Planning Application: Seeking advice on a planning application for this site for 4 Affordable and 1 Full Market home with associated access arrangements.

Reference: **WA/76/17/PL**

Location: **Land south of Wandleys Farm, Wandleys Lane, Walberton**

SITE OVERVIEW AND
VISIBILITY SPLAYS
1:500

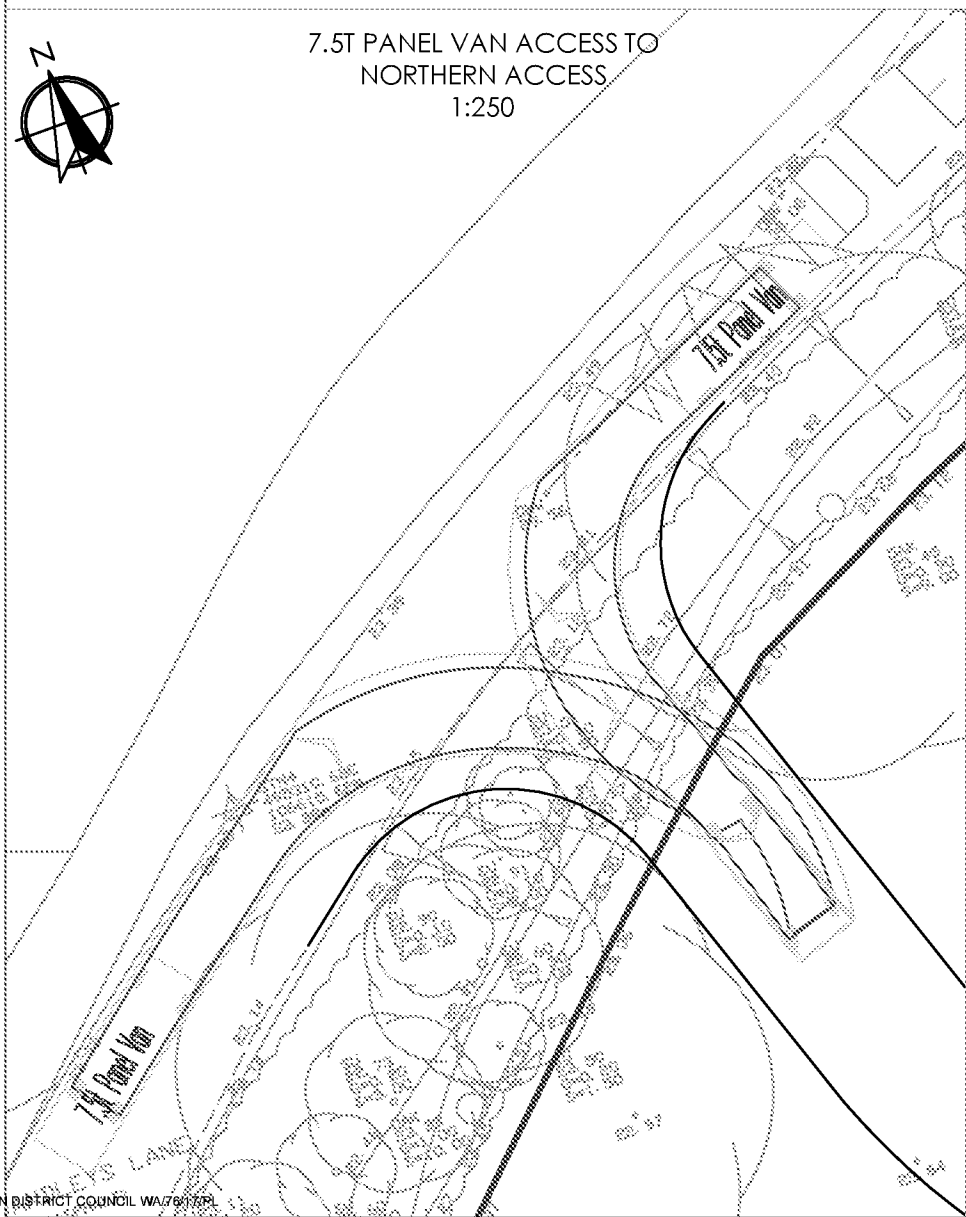
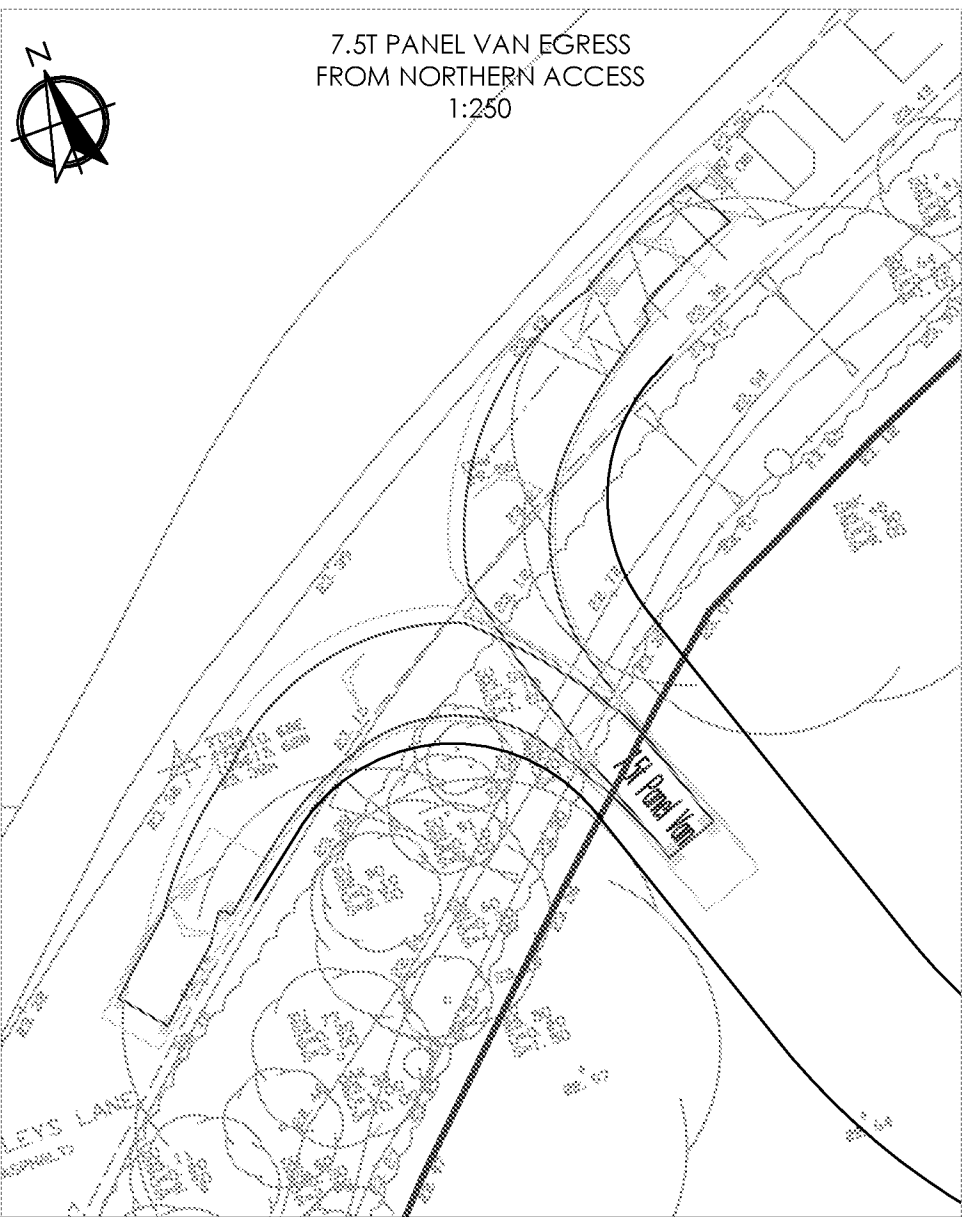
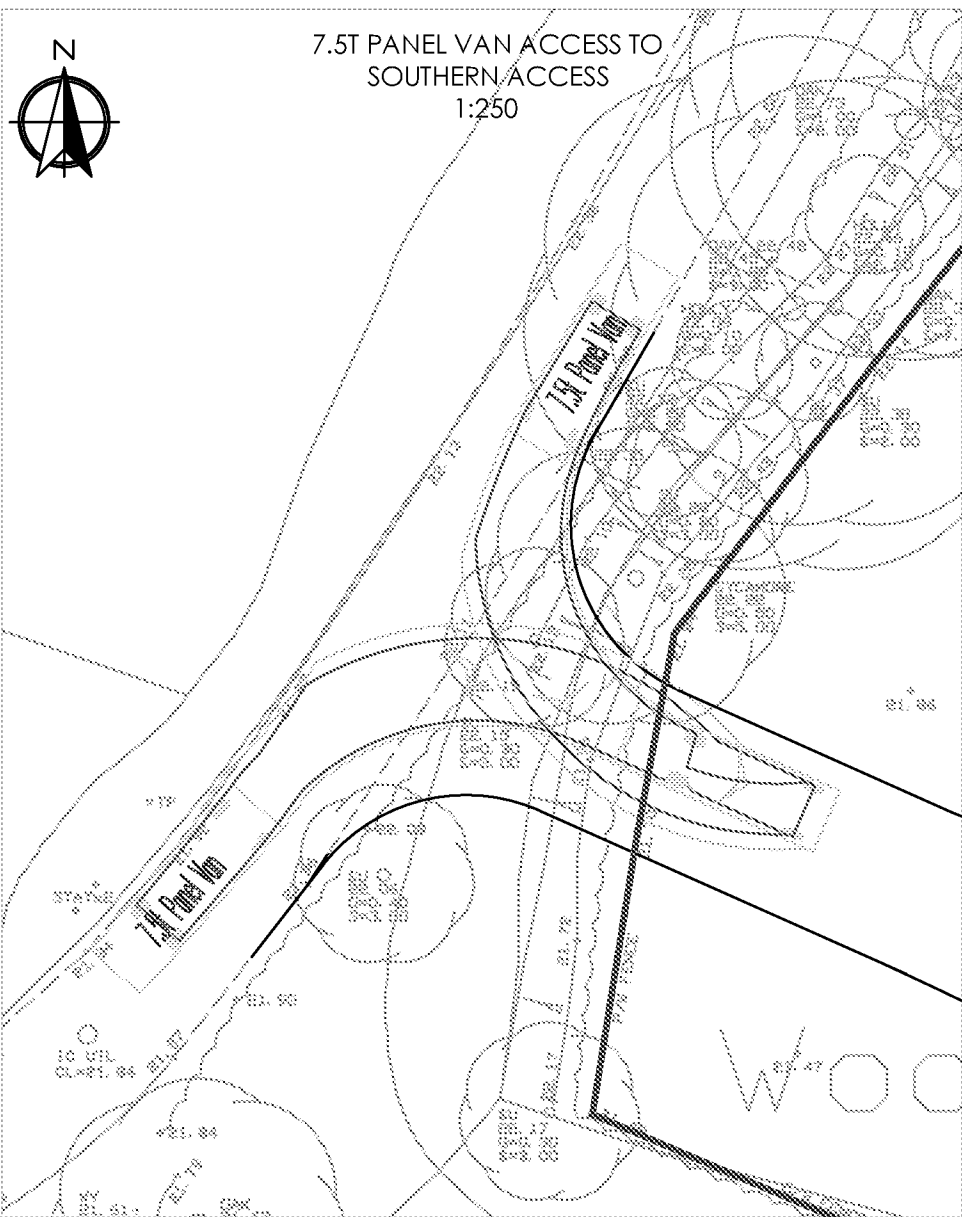
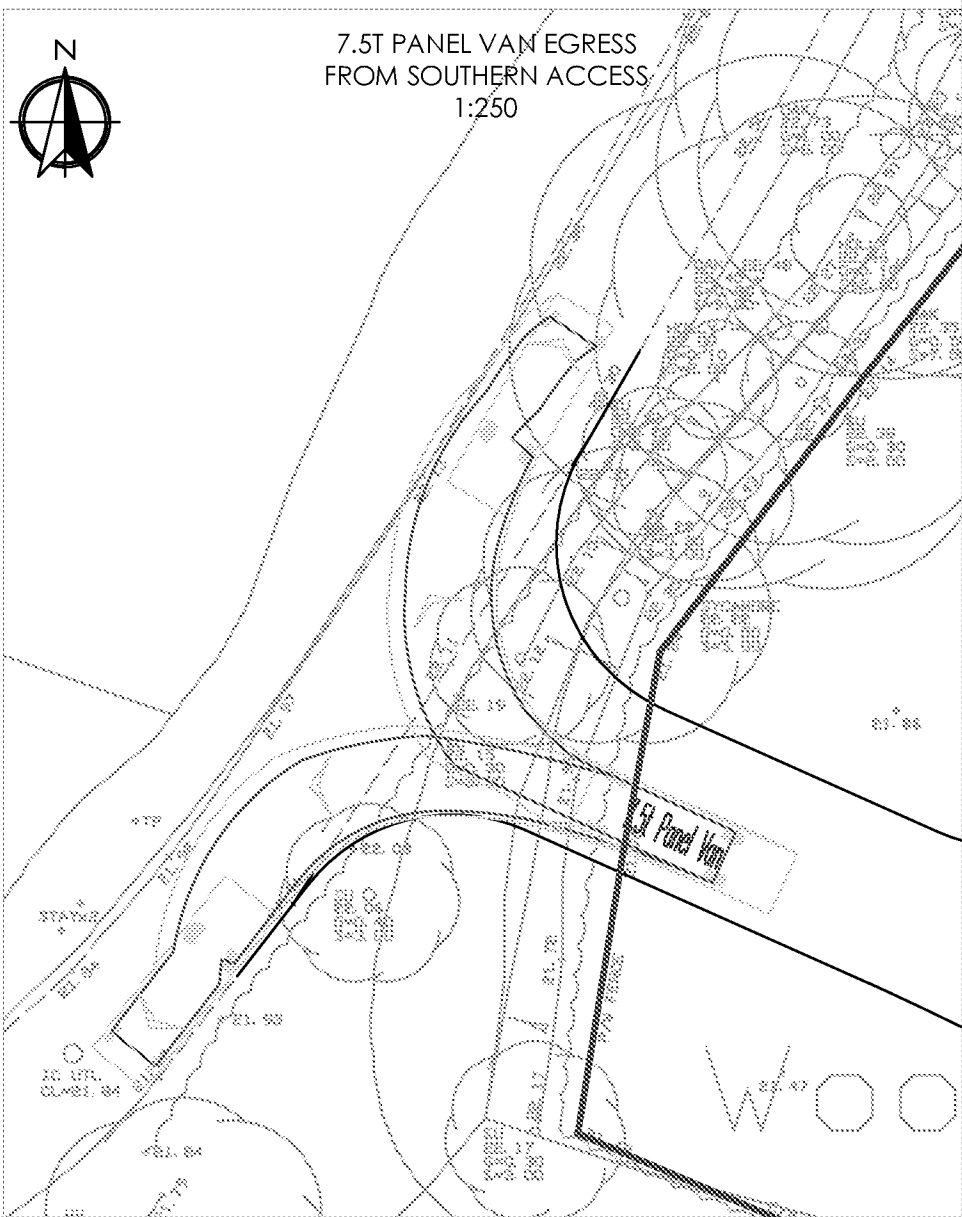
- I do not agree with the grading of T4 Ash as C and would see this as a B grade tree – also some of the Oaks graded as B are in my view A graded trees.
- I believe it should be possible to locate the southern access point outside of the RPA for Oak T8 but this can only be confirmed when they submit an AMS report with TP Plan.
- I find the location of the northernmost access to be unacceptable in arboricultural terms [both the access road and the utility services cut through RPA's] given the threat to valued trees in the landscape and I would suggest that this access is re-positioned to be between T1 & T2 and outside of their respective RPA's.

- I would have to register an **OBJECTION** to this scheme on the grounds that the northernmost access threatens the future of two significant and valued trees in the landscape.
- For this reason I also recommend that a TPO is made to protect the mature Oaks and Ash along this road frontage and include TEMPO forms for this purpose.
- The applicants will need to submit an Arboricultural Method Statement report & Tree Protection Plan in support of this layout.
